Submission to the North West Rail Link EIS 2
SSI-5414
3rd December 2012

West Pennant Hills Valley Progress Association

Figure 6.12 Cherrybrook Station - Indicative vehicle and pedestrian movements

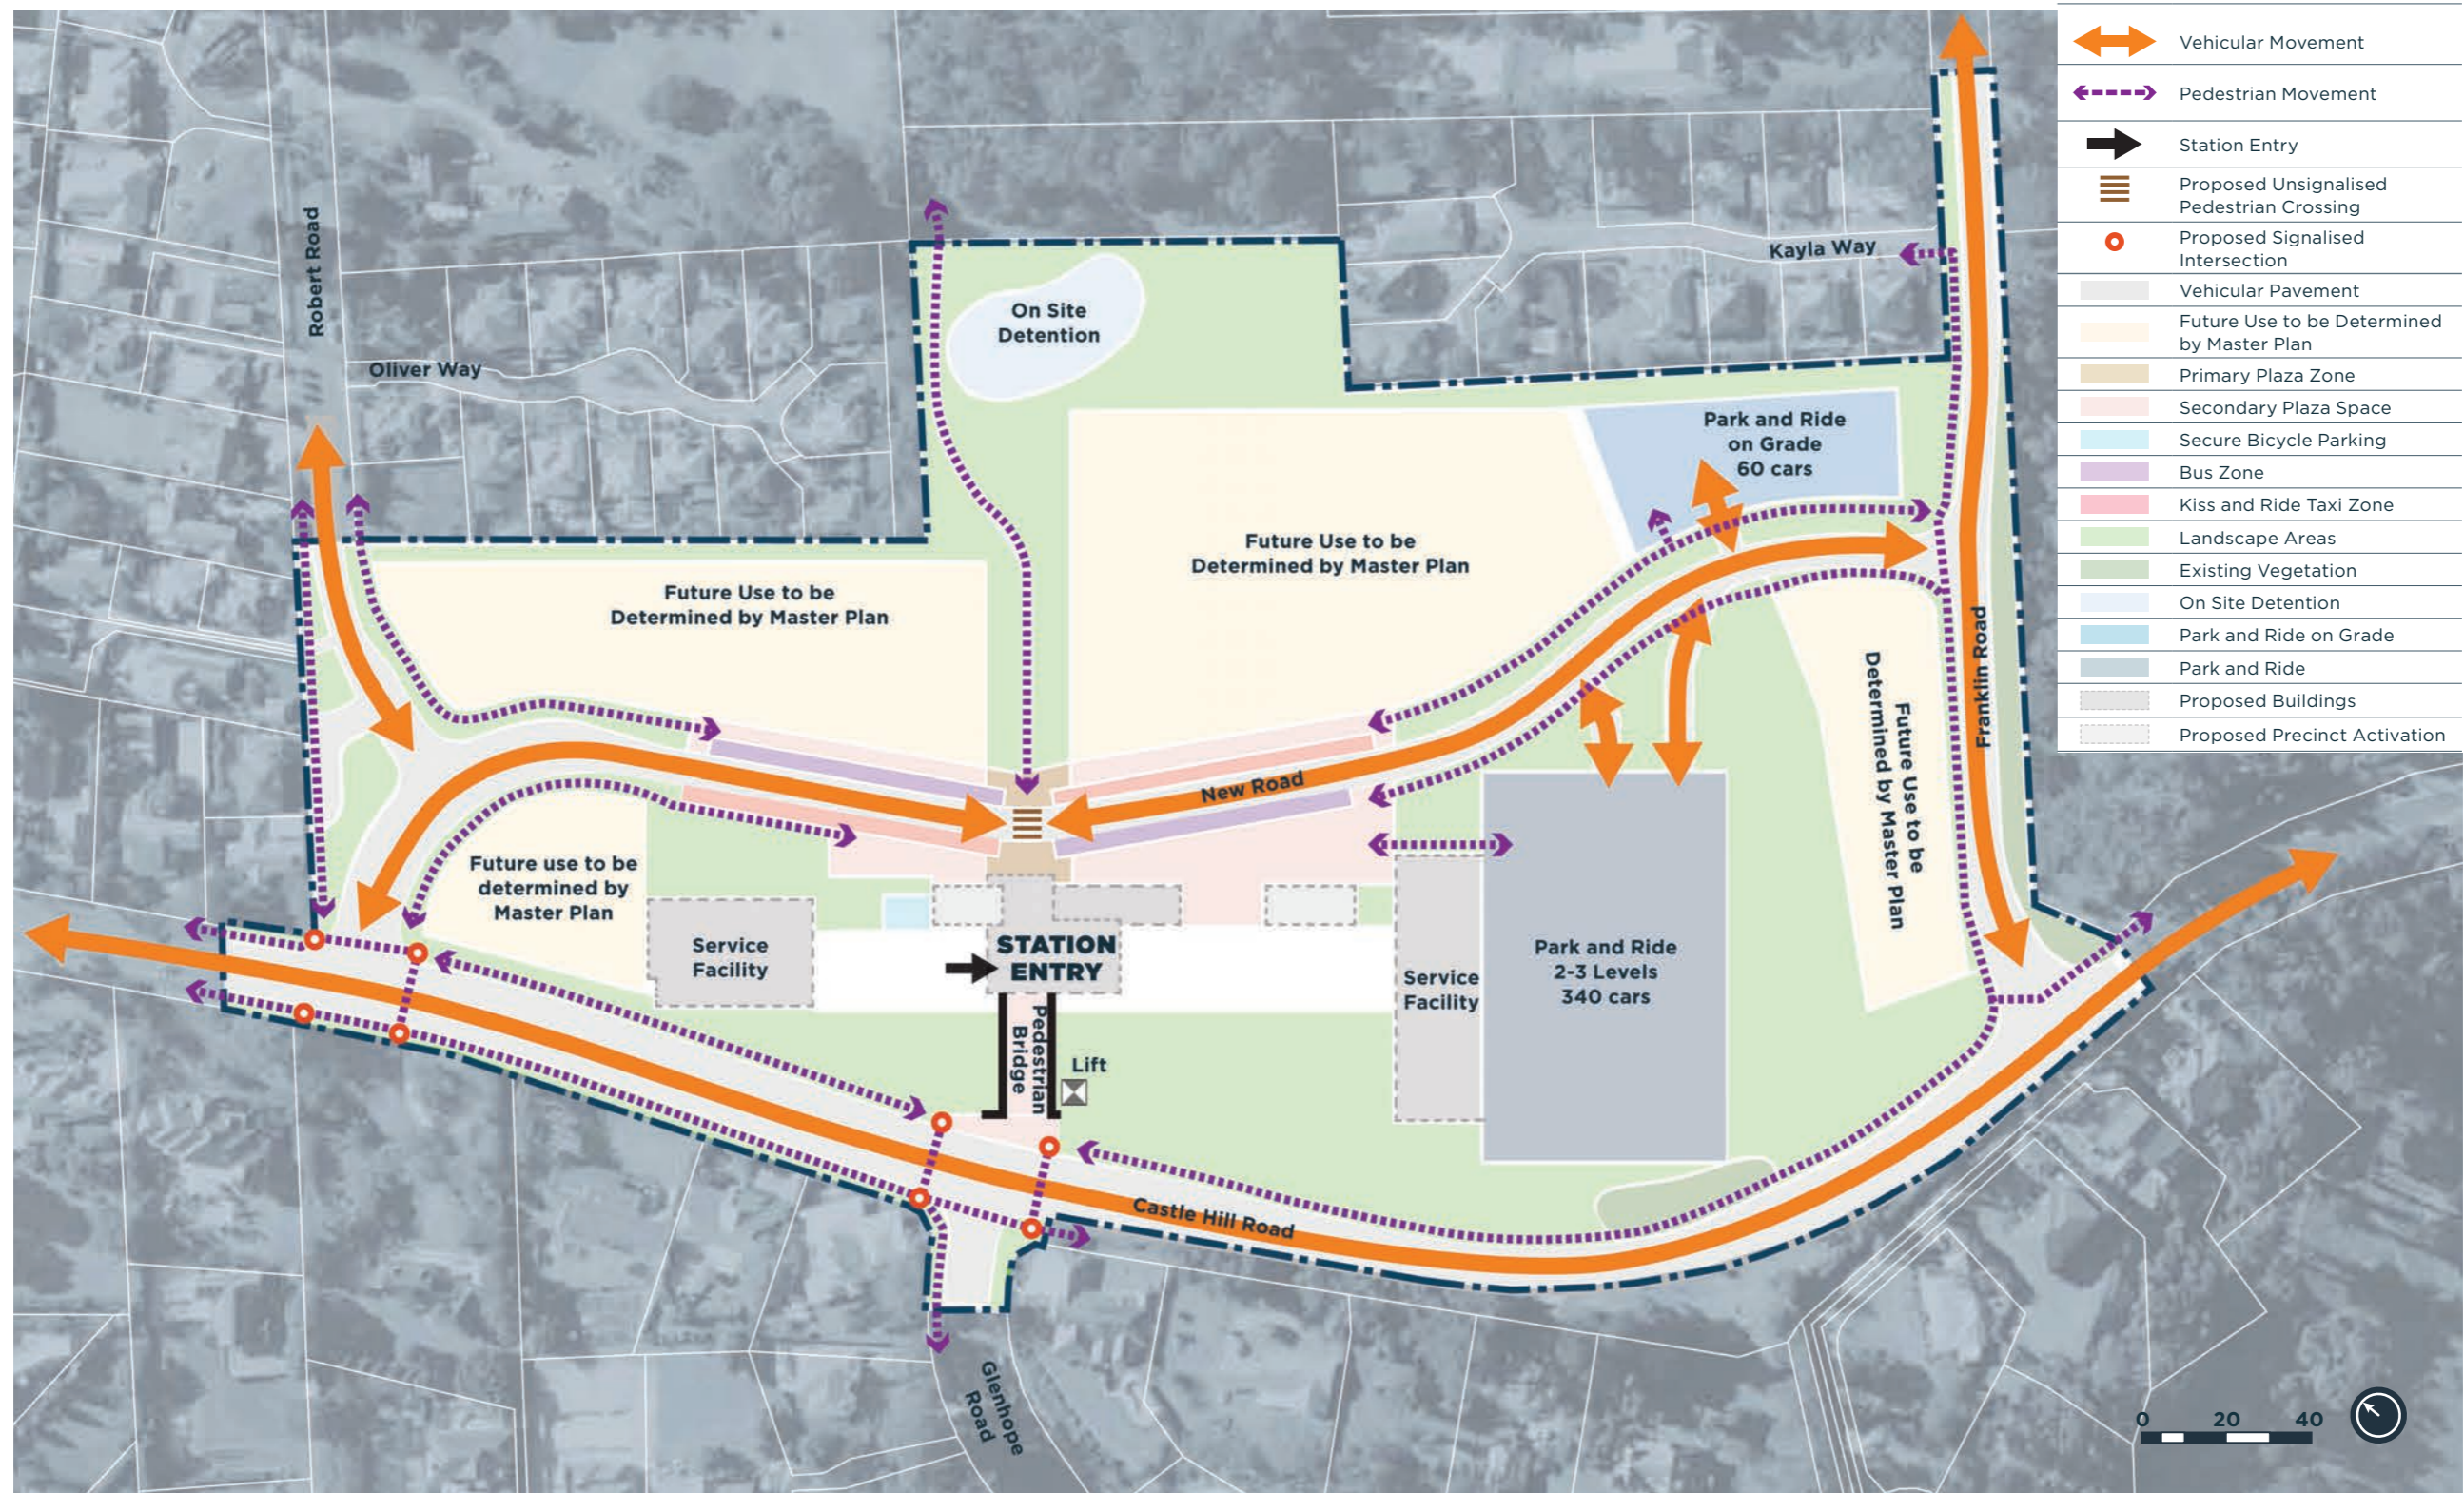
Once Cherrybrook Station is operational, it will be important to maintain unhindered traffic flow along Castle Hill Road. With the addition of two sets of traffic lights plus the extra traffic generated by the Station, it will be necessary to ensure that all measures are taken to reduce the number of times that traffic on Castle Hill Rd is stopped by vehicles, buses and pedestrians trying to access the Station..

1. grade separated pedestrian access from south of Castle Hill Rd be provided at Glenhope Rd
2. kiss and ride parking bays be provided on the south side of Castle Hill Rd within easy walking distance of the grade separated pedestrian access
3. bus bays on the south side of Castle Hill Rd be positioned in a similar location

An extra lane on the south side of Castle Hill Rd could be accommodated to allow these facilities by moving the northern edge of Castle Hill Rd during the station construction phase.

Grade separated pedestrian access is essential to prevent pedestrians taking risks to cross slow moving traffic, and thereby being a danger to themselves and a hazard to drivers.

It would appear that little consideration has been given to access to Cherrybrook Station from the WPHV. While it is appreciated that the majority of patronage for the NWRL will come from north of Castle Hill Rd, it is highly likely that there will be significant movement from the south. The misunderstanding by the EIS document of WPHV resident needs is well demonstrated by its assertions that the feeder roads serving the WPHV are Old Northern Rd and County Drive. Both these roads approach Castle Hill Rd from the north and do not serve the WPHV. It is therefore clear that the EIS has given no serious consideration of our access requirements to the Station.

For instance, the nominated route for the potential shuttle bus service from the WPHV has not been properly thought through. The problem is that Highs Road is two lanes at its intersection with Castle Hill Rd, and is only 2 lanes for about 30m when it reverts to one lane each way. Heading north or turning right at Castle Hill Rd is a challenge, with the green phase being barely enough to let 3 cars through. Due to the shortness of the lane, and the majority of the traffic heading west/left turn, traffic flow comes to a standstill, especially during the evening peak periods. A shuttle bus would be lucky to clear the intersection during the green phase in the morning peak and it would then sit in traffic until Franklin Rd. A much better option would be to access Castle Hill Rd via Glenhope Rd or Coonara Ave, drop off passengers in the proposed bus bay on the south side of Castle Hill Rd and return via Highs Rd. This would not only form a functional loop, it would also cover a greater area of the WPHV. In addition, there would be no need for the shuttle bus to enter the congested Station precinct. Likewise, kiss and ride patrons could avoid the Station precinct if there was a facility for them on the south side of Castle Hill Rd.
